From: Sue Howell
Sent: 10 April 2019 15:49
To: Michael Eastham
Subject: RE: AL/129/18/OUT Greenspace clarification

Please see the email from the applicant below, which is a reply to your consultation response to AL/129/18/OUT – Land East of Orchard Gardens, Woodgate.

Appendix II: proposed site

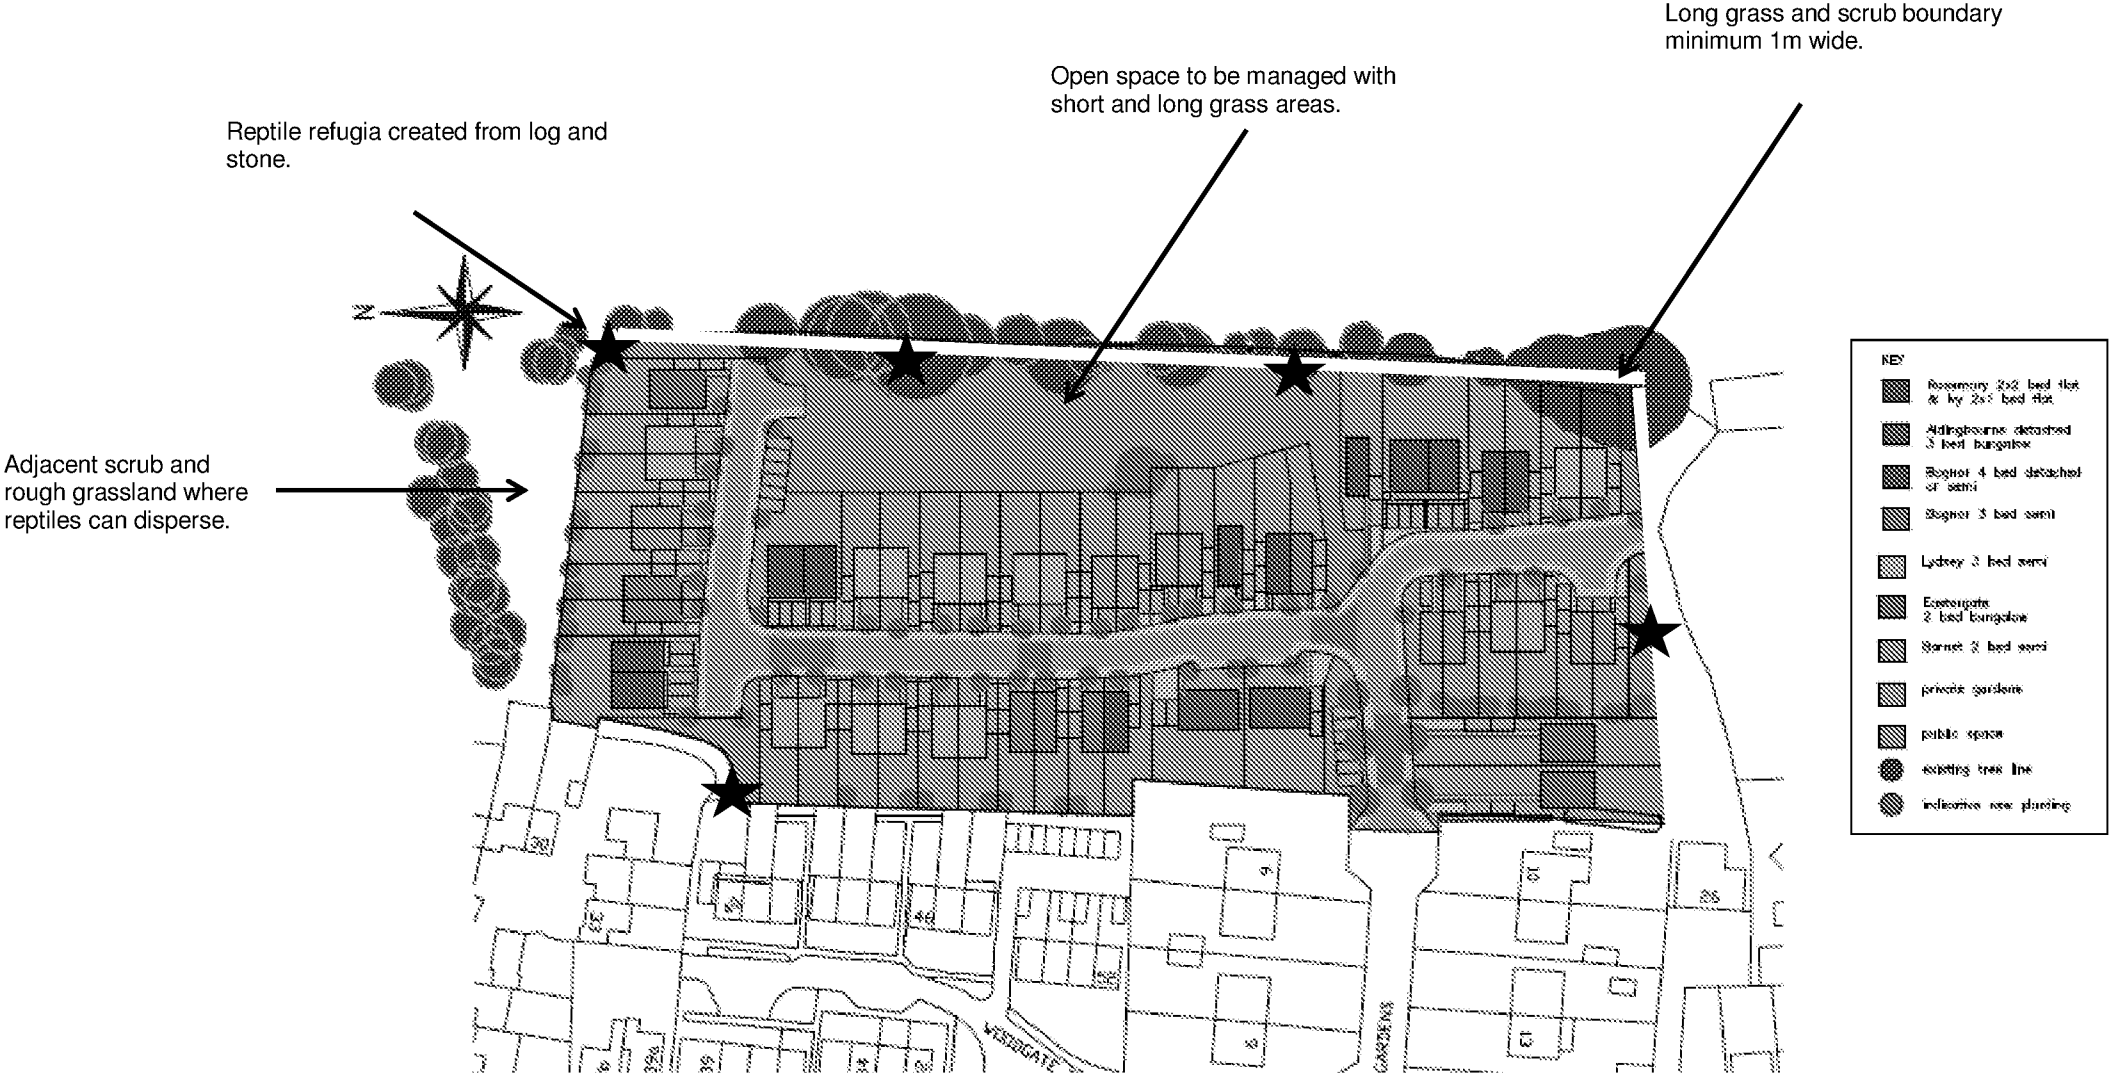
In response to the justification for the positioning of the POS, I accept the reasoning whilst not wholeheartedly agreeing that this makes the best layout. I agree that by positioning the POS to the east then it does allow for the TPO'd and other trees to remain without conflict which would occur if these were sited within back gardens; this I feel is the primary benefit of POS in this location. A row of back garden fences does not in my opinion form a nice edge to an area of POS and does in my view to some extent segregate this area from the development as a whole. I don't tend to agree either that the central roadway and the POS will afford views to the Downs, as these views will in fact be blocked by the houses positioned to the north as shown.

I would not recommend an objection to the proposals based on the benefit to the retained trees and the inclusion of these within the POS, but would register my opinion that the layout of the dwellings are not in a position which would benefit greatly from the POS asset.

Consideration was given to having a central Public Open Space (POS). Review of other developments completed over the past few years shows relatively sterile central green spaces with little biodiversity and little opportunity for adventurous play or discovering nature.

The layout provides for the POS to be viewed from the properties to the north, the living rooms of the flats and from the wide public path leading into it at the south end. The response to the Police consultation does not regard the public open space position as problematical providing robust fencing is provided. That could be conditioned.

The position of the open space, as well as connecting to the existing tree/ditch line, allows for a straight north to south street providing a view towards the downs from the street and from the open space. This type of layout, as opposed to cul-de-sacs, also allows residents and their children, to see and greet each other and can give rise to a better sense of community.
